CITY OF ALBUQUERQUE

September 5, 2012

**Re: Boulders Phase I and II
Grading and Drainage Plan
Engineer's Stamp Date 8/28/2012 (B11/D001C)**

DRAWN BY  
DY  
DATE  
9-06-12  
DRAWING  
OVERALL GRADING  
SHEET #  
**3**  
JOB #  
2011005

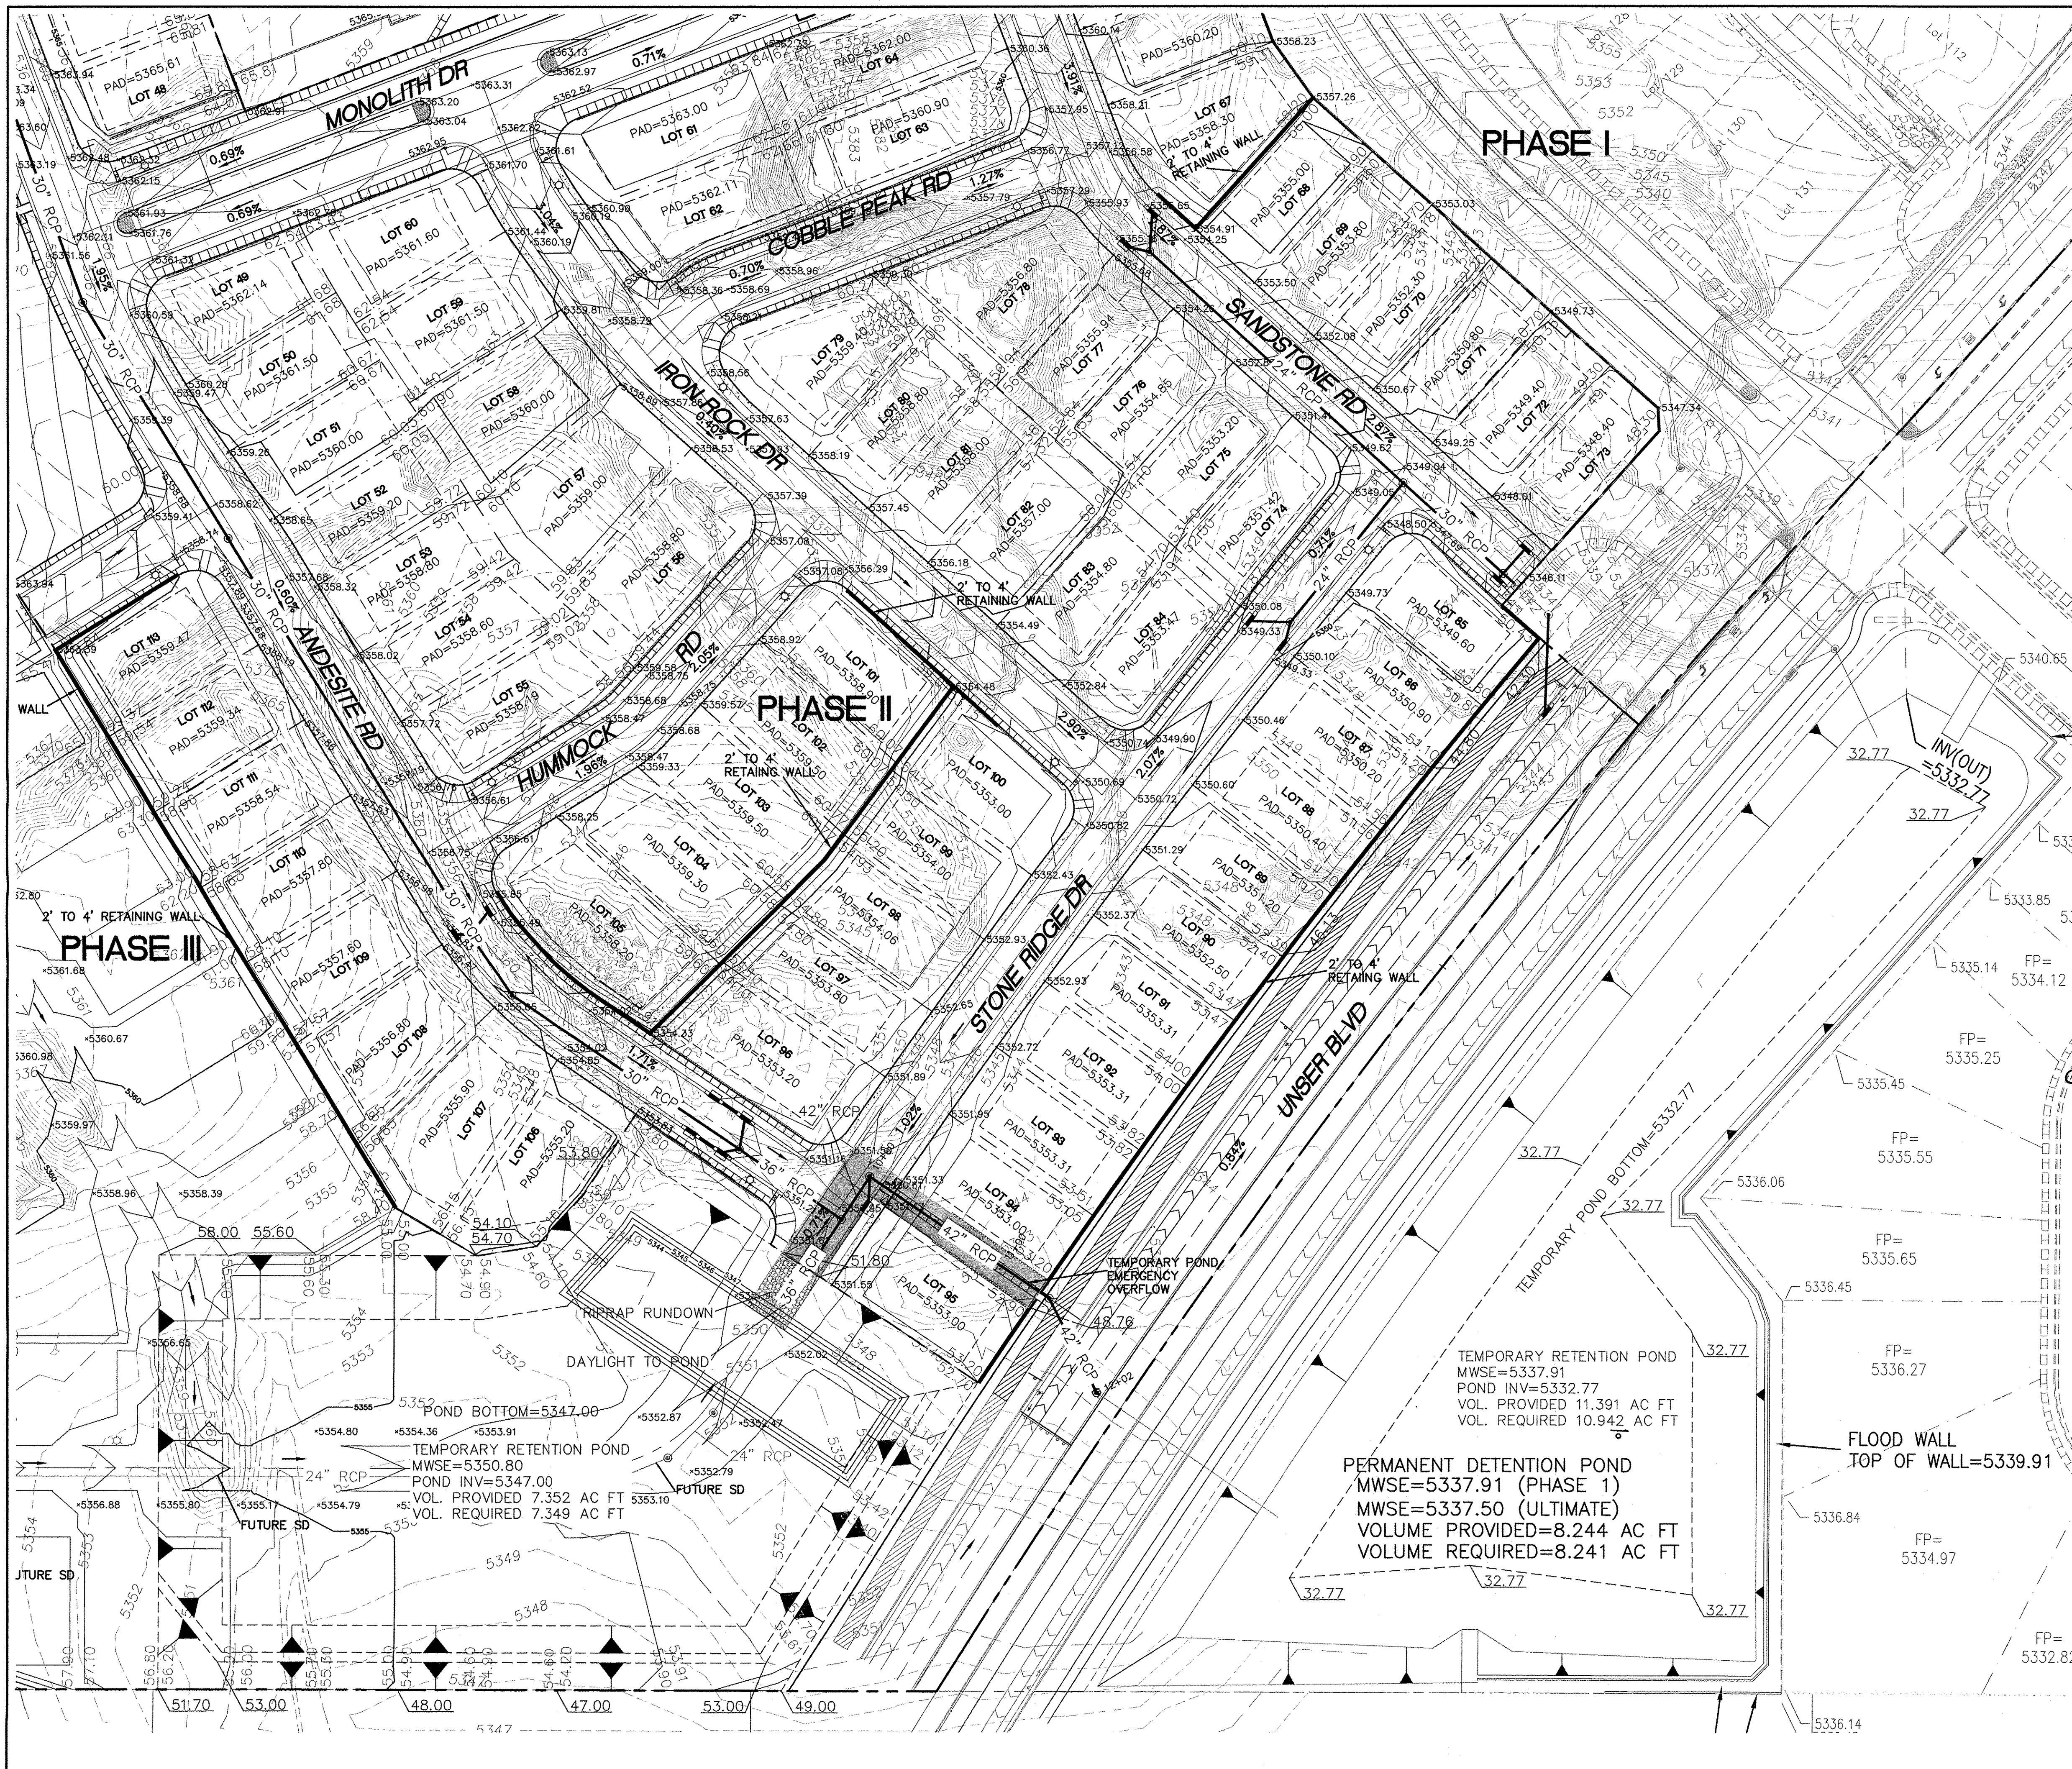
- Check the grades along Big Rock Dr. right-of-way. Retaining walls may be required.
- Check the grades on the north side of Lot 21. The existing contour is shown at 5381 and spot elevation is at 5375.94.

- Proposed concrete channel between Lots 29 and 30 should be constructed to City Std. DWG.# 2260. Provide channel flow capacity calculation.
- Storm drain pipe should be extended to intercept the 34 cfs at the south end of the channel.

- Show the spot elevation at the entrance to the school to assure water block is provided.
- Show the flow line elevations along Paradise Boulevard by the Big Rock Dr.

- Riprap may be required at the south end of the Big Rock for erosion protection.
- Call out top of wall and top of footing for the retaining walls on the grading plan. Please make sure that the footing will not be exposed along Unser Boulevard or any other public roads.

- Please provide as-built elevations for the exiting retention pond.
- Modify the infrastructure if necessary to reflect the proposed changes on the grading and drainage plan.
- Where is the emergency overflow for the proposed retention pond west of Phase II.
